Rezoning Transportation Analysis

Petition Number: 2023-080

From: Jake Carpenter, PE
Jacob.carpenter@charlottenc.gov
980-221-5675

Date	Description
8-24-23	First Review (JP)
9-20-23	Second Review (JP)
10-26-23	Third Review (JP)
12-20-23	Fourth Review (JP)
1-24-24	Fifth Review (JP)

GENERAL NOTES FOR PETITION (2023-080)

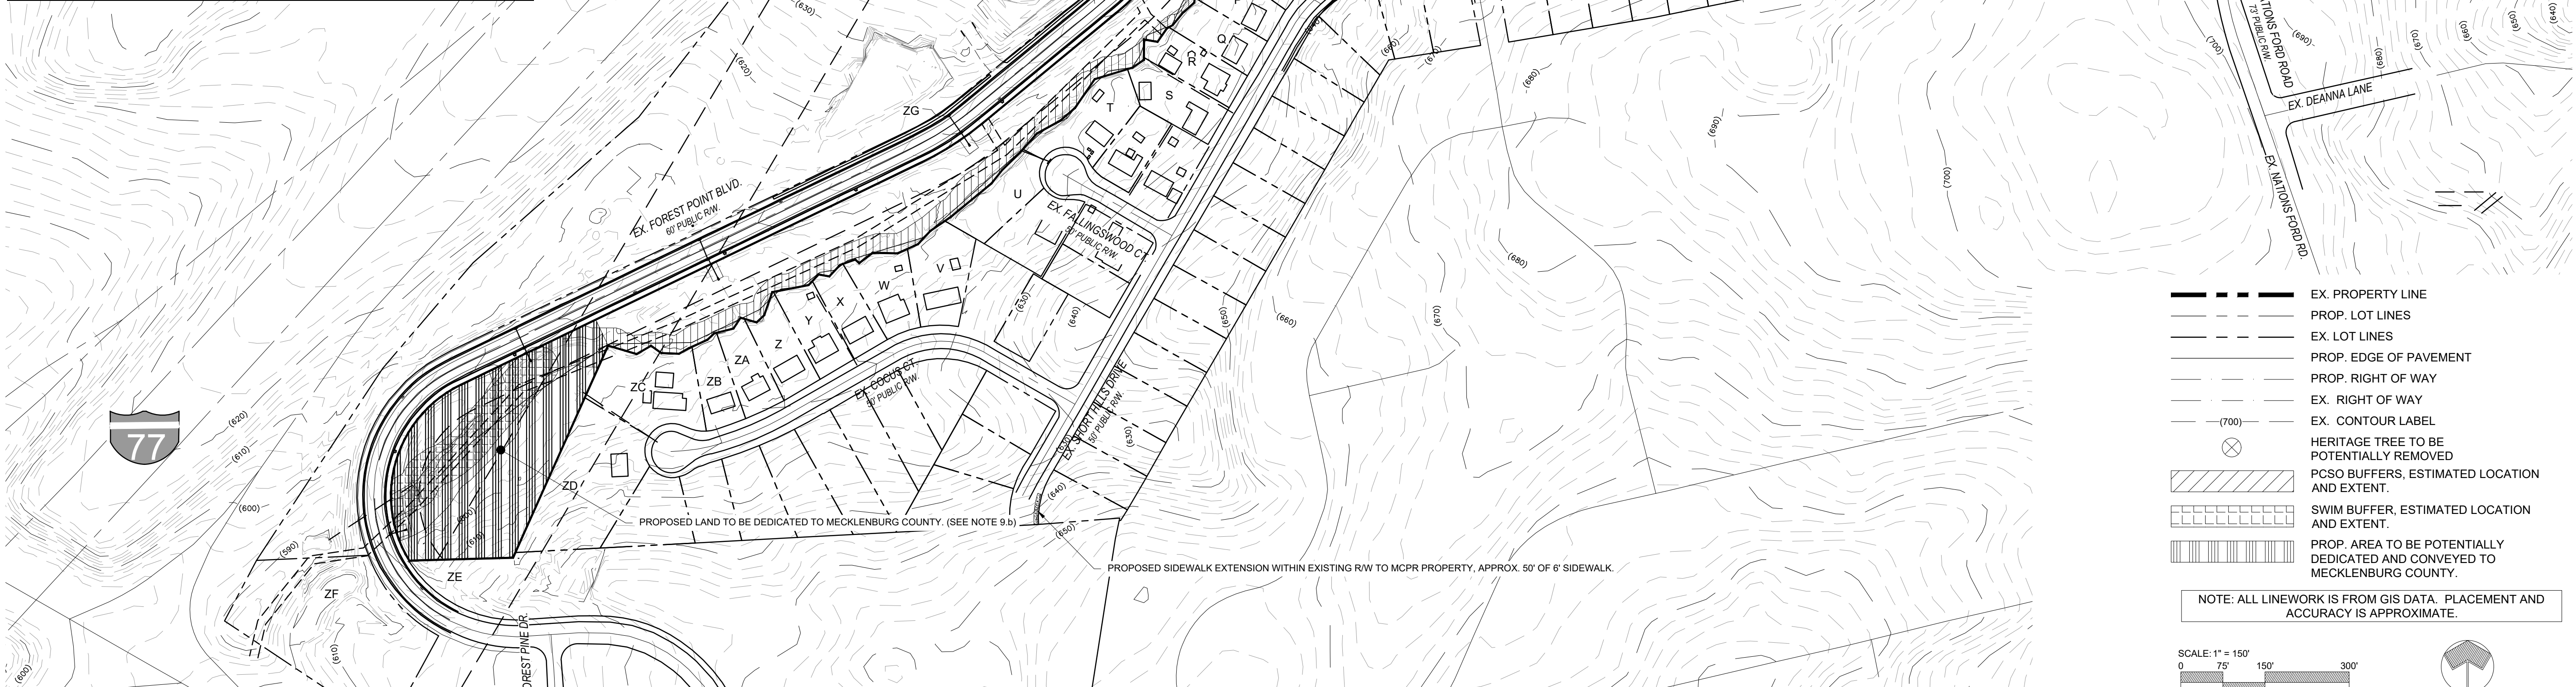
9. **New Comment 10.26.23:** 35'x35' sight triangles are no longer in the sight distance policy, this should be 50'x50' sight triangles.

- 5.f. ~~SHALL MEET, PER THE CITY OF CHICAGO'S CURRENT REQUIREMENTS.~~
ADEQUATE SIGHT TRIANGLES MUST BE RESERVED AT THE EXISTING/PROPOSED STREET ENTRANCE(S). TWO 35' X 35' SIGHT TRIANGLES (AND TWO 10' X 70' SIGHT TRIANGLES ON NCDOT-MAINTAINED STREETS) ARE REQUIRED FOR THE ENTRANCE(S) TO MEET REQUIREMENTS. ALL PROPOSED TREES, BERMS, WALLS, FENCES, AND/OR IDENTIFICATION SIGNS SHALL NOT INTERFERE WITH SIGHT DISTANCE AT THE ENTRANCE(S) AND SHALL BE IDENTIFIED ON THE SITE PLAN.

CROPPED FROM BEST U-02B2.3

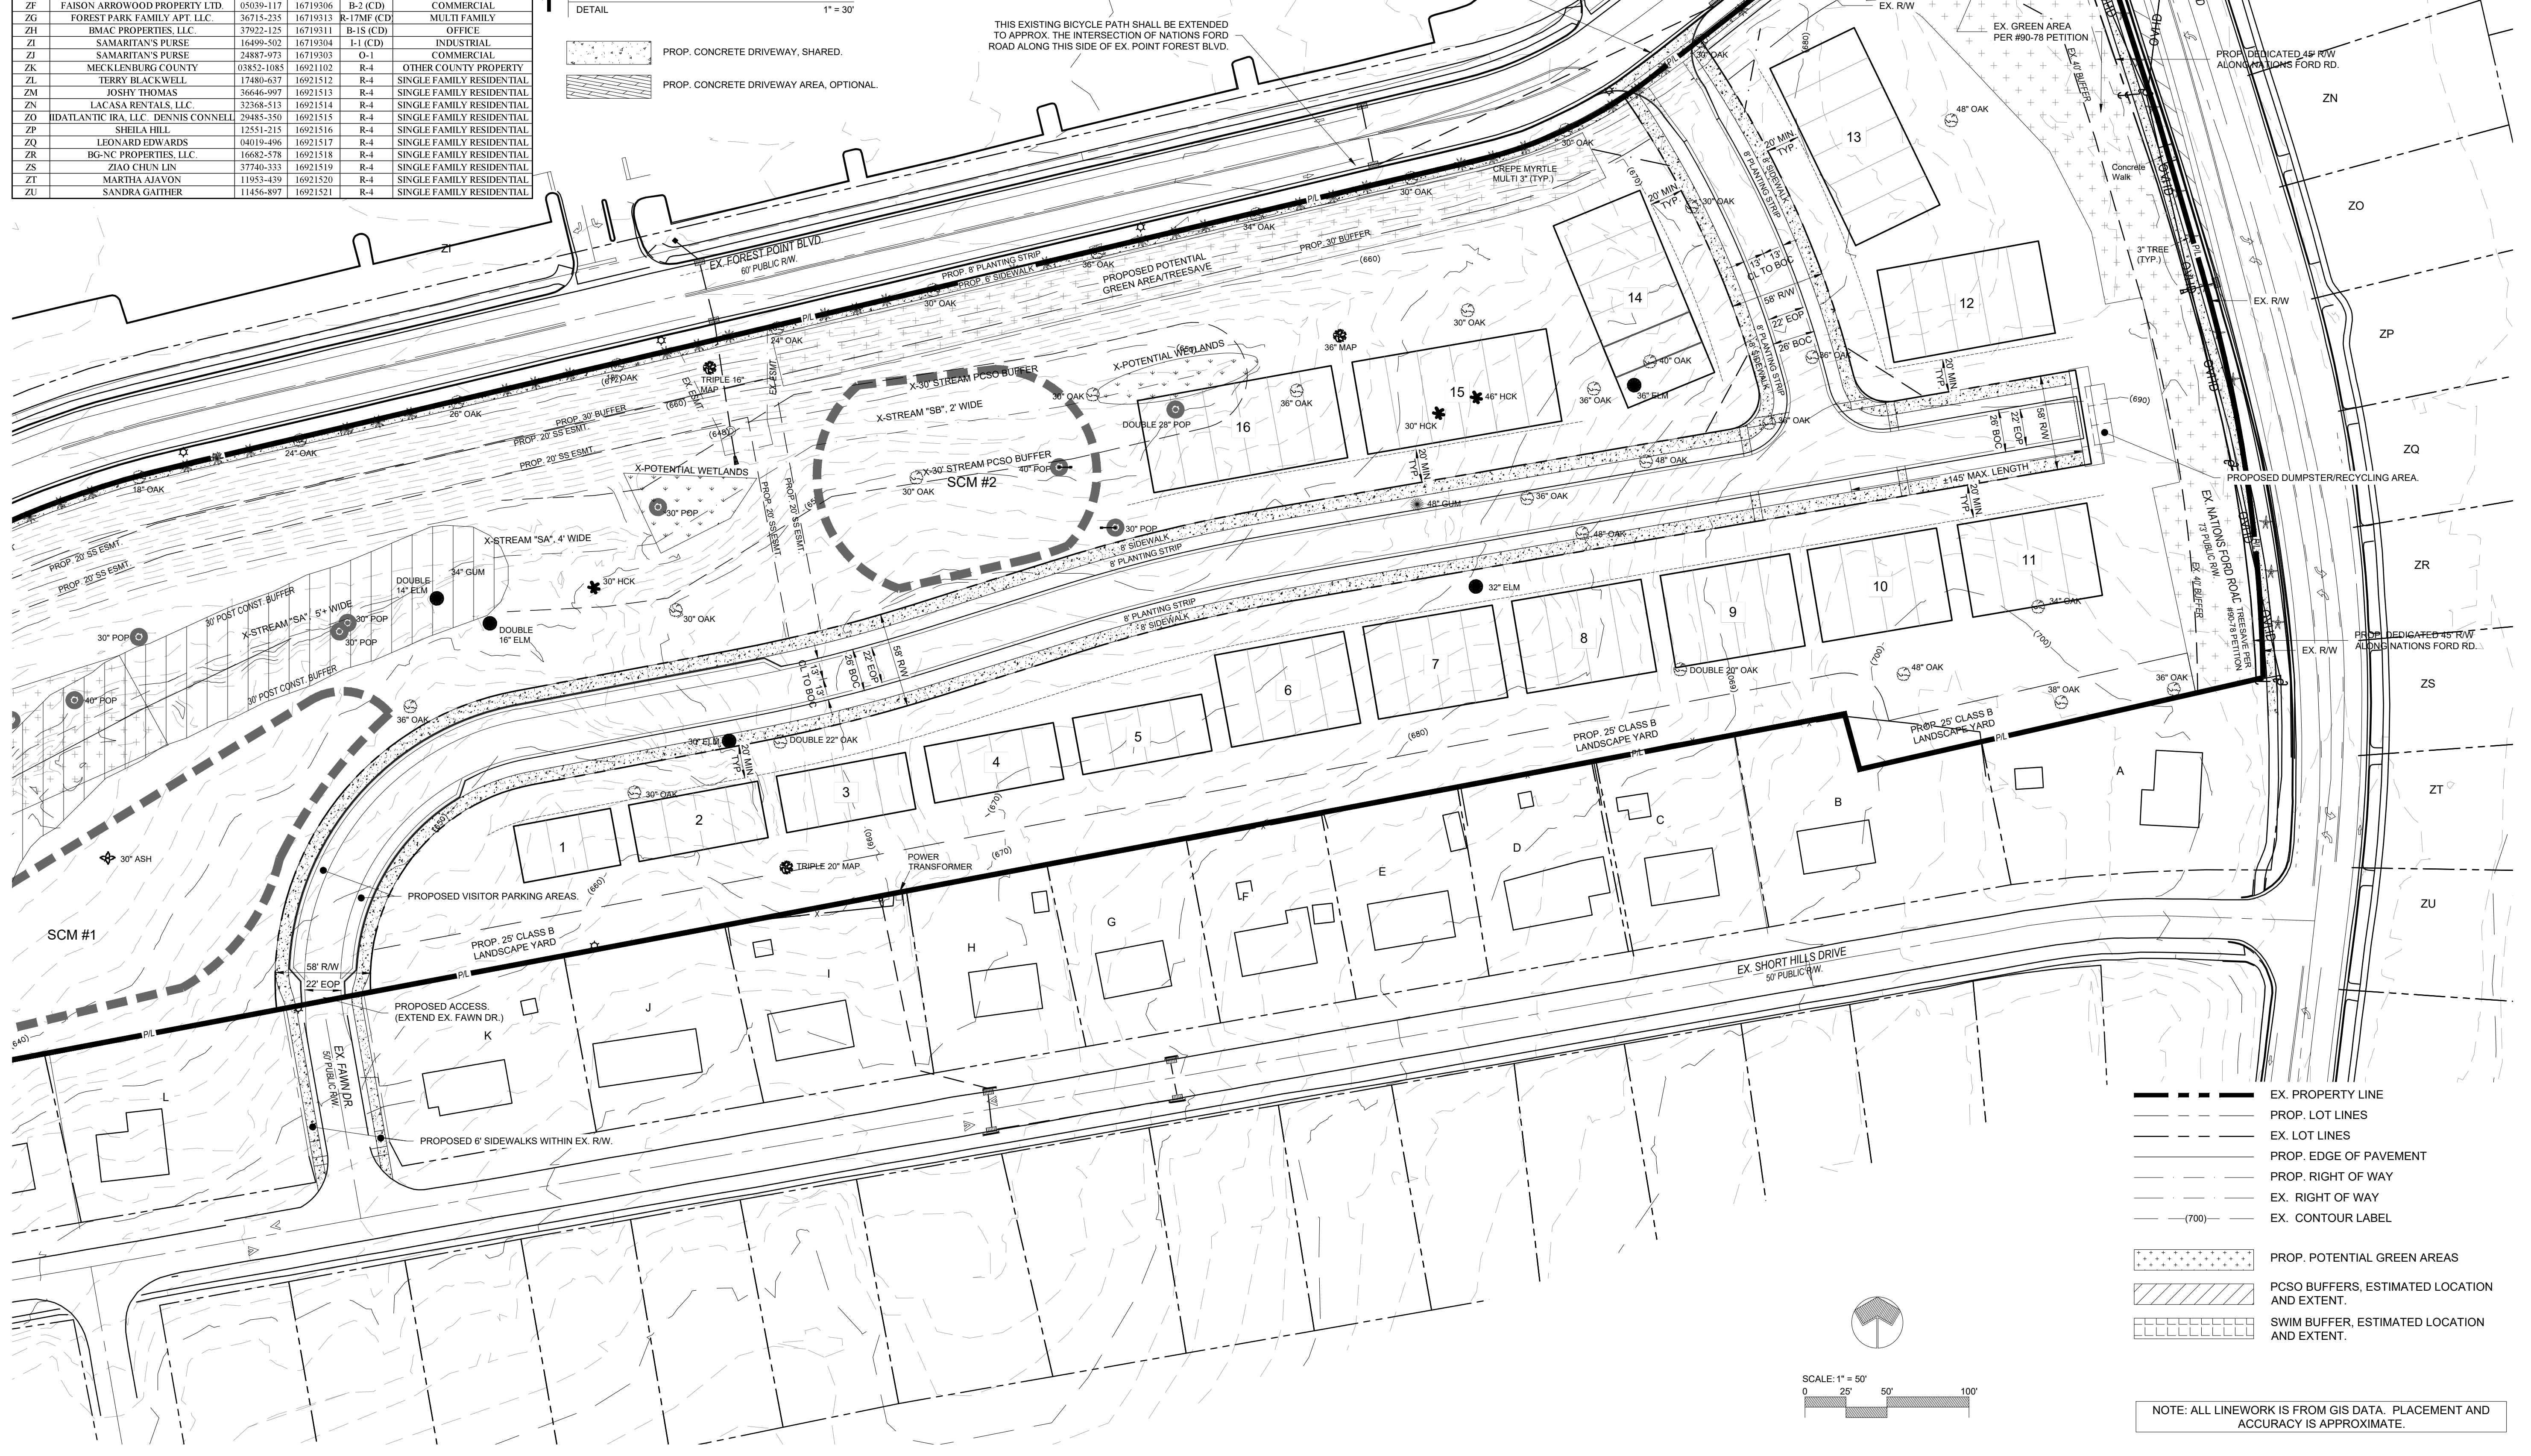
Clarifying Comment 10.26.23: From the centerline of Forest Point, label and dimension the ROW and back of curb.

Label and dimension the curb and gutter from the centerline for each road on the site plan.
